Response to: BEIS Document EN10078 dated 20th December 2021
Interested Party Identification 20024089 & 20024090, 20023648 & 20023049
Relevant Representation Nos RR-804 & RR805

Detailed Response to SPR Document EA1N-DGR-ENV-REP-IBR-000002 & EA2N-DGR-ENV-REP-IBR-000002 – dated 30th November 2021

East Anglia ONE North and TWO
Outline Operational Drainage Management Plan
Environment Agency Flood Zones

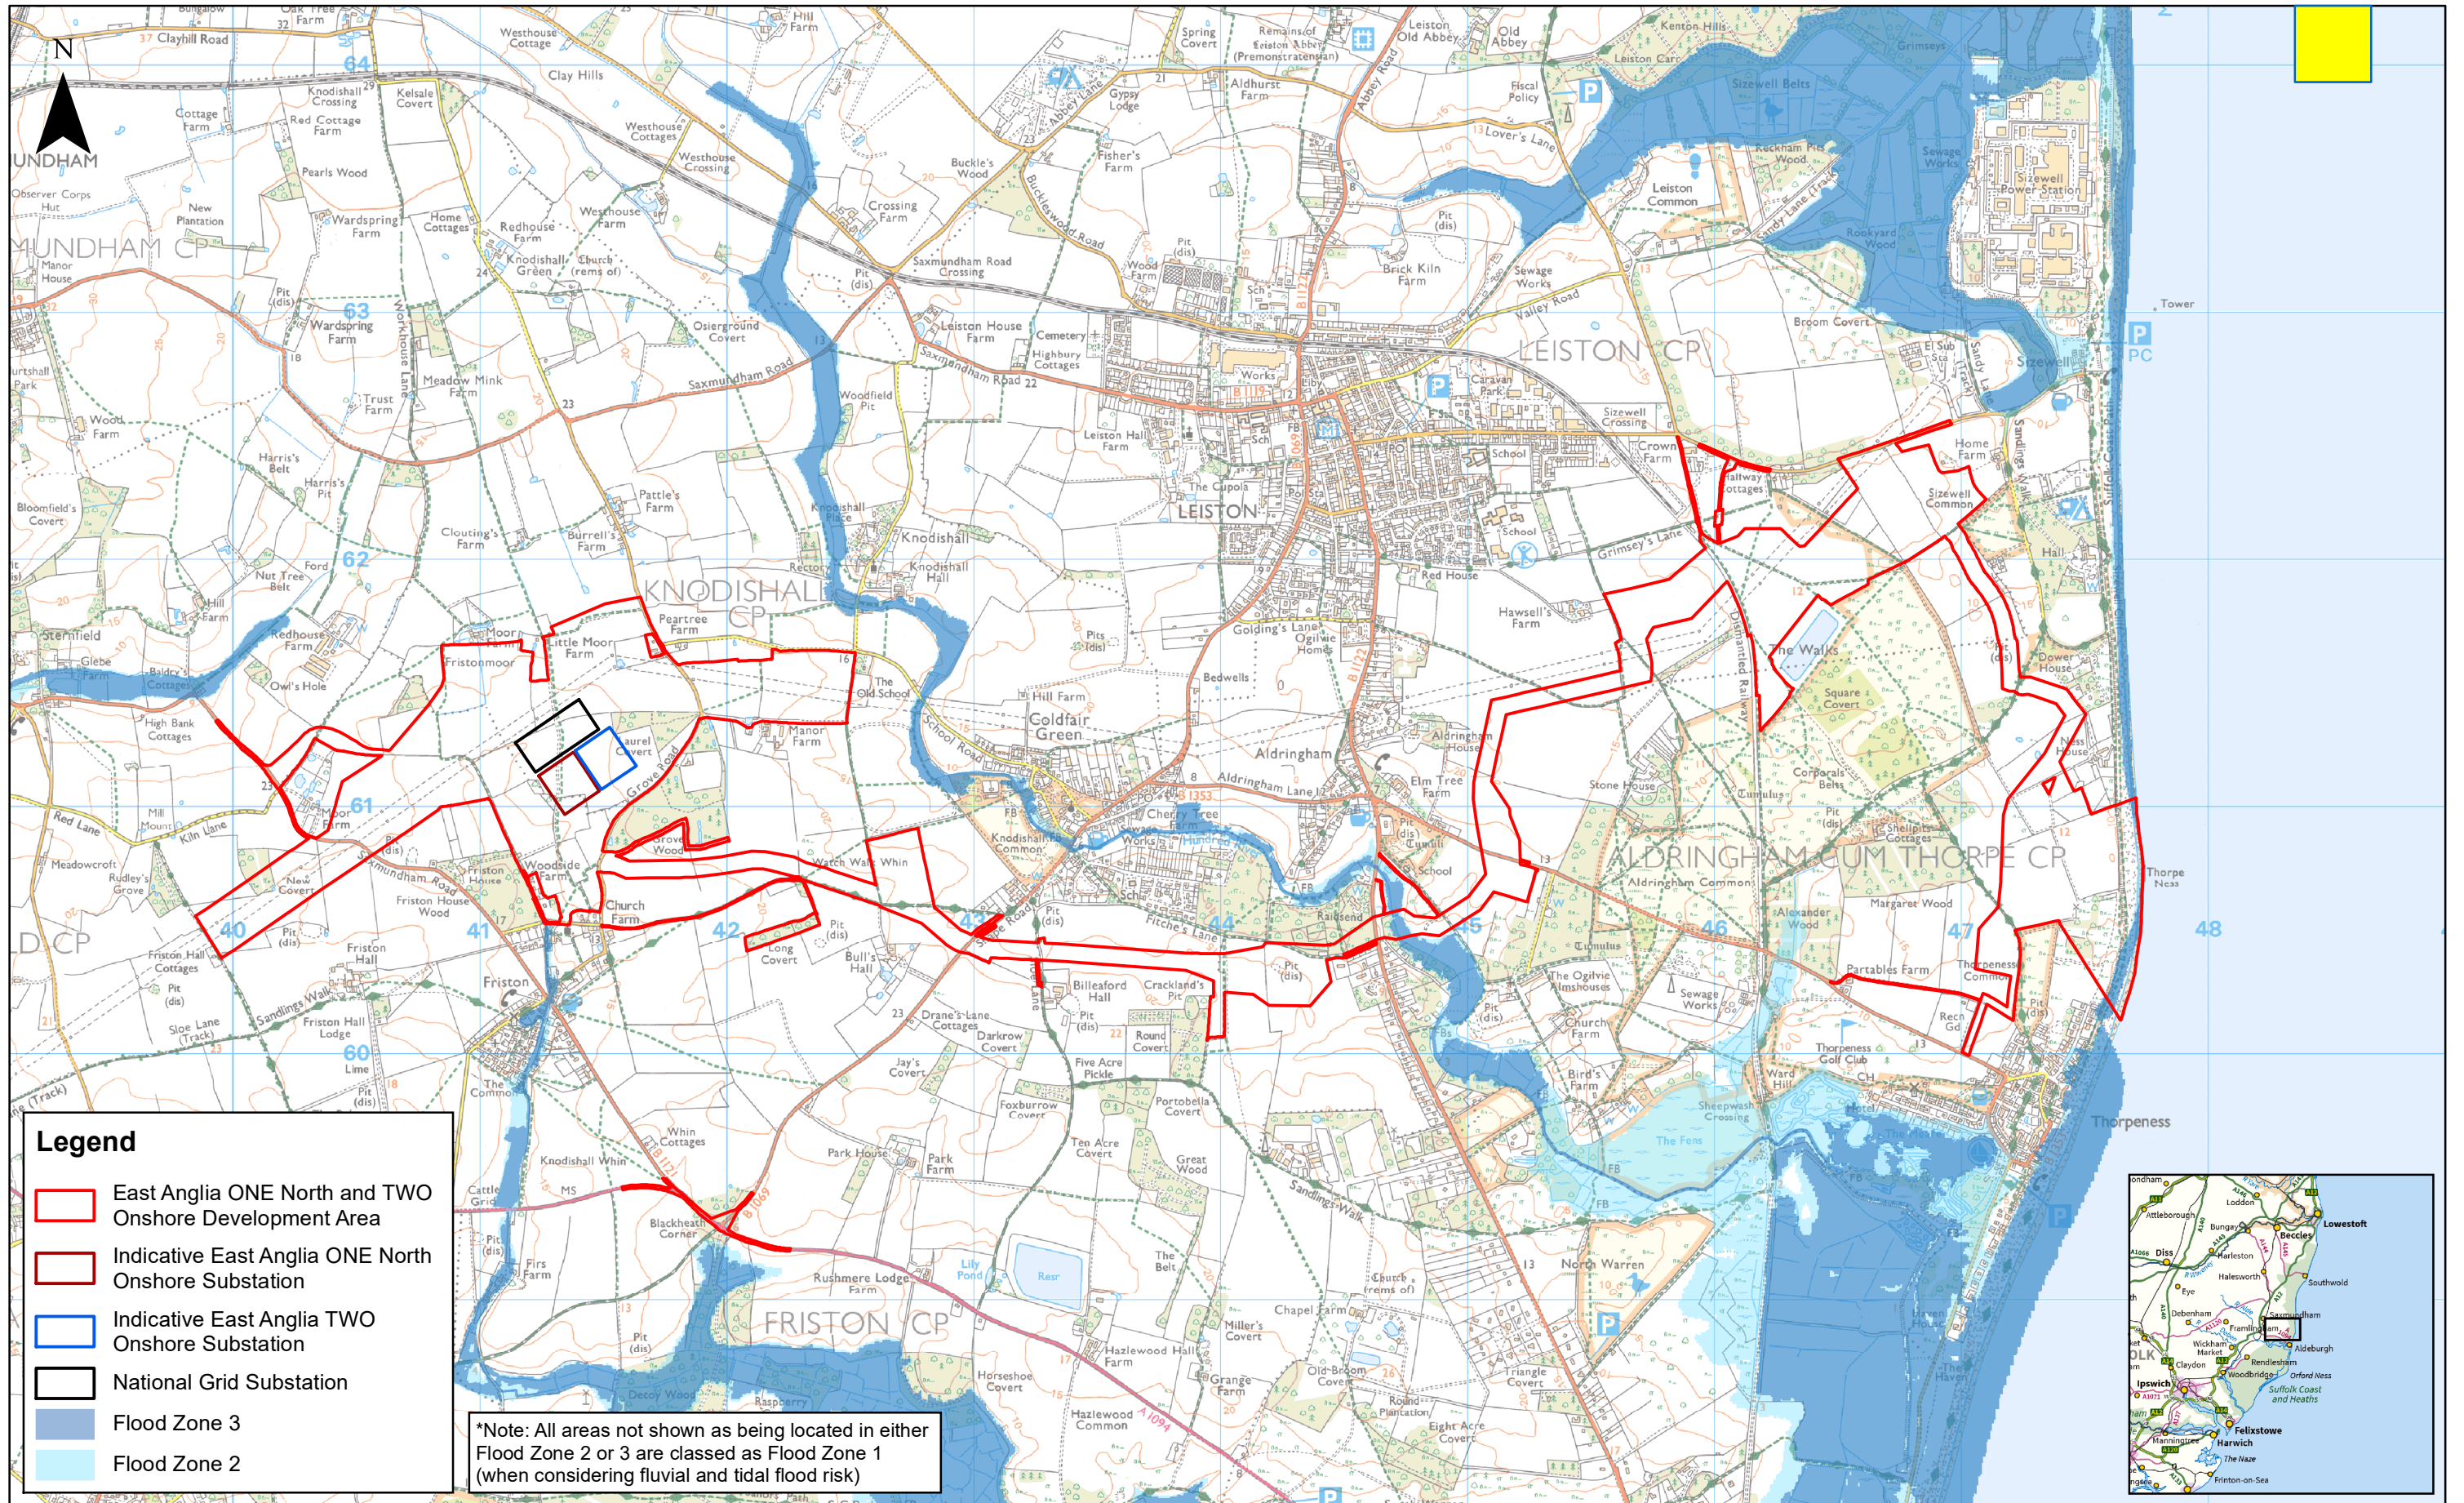
5. SPR chose the site at Friston on the basis of it being a Flood Zone 1 area, ie the risk of *fluvial* flood event being <1:1000, which is to be expected, given that it lies some 5 km from the nearest river/tidal section of water and some 20 metres above it! The Applicant has made repeated attempts to mollify the concerns of local residents that the construction of the substations will not lead to the increased risk of flooding in the village, and failed to acknowledge that the choice of the site was flawed from the outset. The OODMP provides little comfort as the prospective SuDs ponds appear to be sized to within a few cubic metres of the maximum requirement, itself based upon limited statistical information regarding rainfall and flow prediction modelling techniques – [see OODMP footnote 4].

12	Operation of the Projects Outline Operational Drainage Management Plan (OODMP)	This response draws to the attention of the SoS to following paragraphs within the OODMP as cited (REP13-020), which reinforce the contention that inadequate attention was paid by the Applicant to pluvial flood risk at Friston as part of the site selection process. <i>53. Subsequent information received from the LLFA (19th November 2019) has indicated that more recent surface water flooding events (occurring in October 2019) has affected the area around Friston.</i>

<p>54. <i>There is a known (variable) risk associated with surface water flooding in proximity to the onshore substation and National Grid infrastructure.</i></p> <p>55. <i>The Product 4 data package (Annex 1 of Appendix 20.3 Flood Risk Assessment) obtained from the Environment Agency does not indicate any records of flooding in the location of the onshore substations or the National Grid infrastructure. The Environment Agency indicate, in their Product 4 data package, that although there are no records of flooding, this does not mean that it has not been subject to flooding, only that no flooding has been reported to them in this location.</i></p>
13	Catchment Hydraulic Model	No evidence is presented to confirm validity of this model in the context of the proposed development site and the drainage of the watercourse through Friston to its entrance to the river Ore/Alde at Ham Creek (tidal)
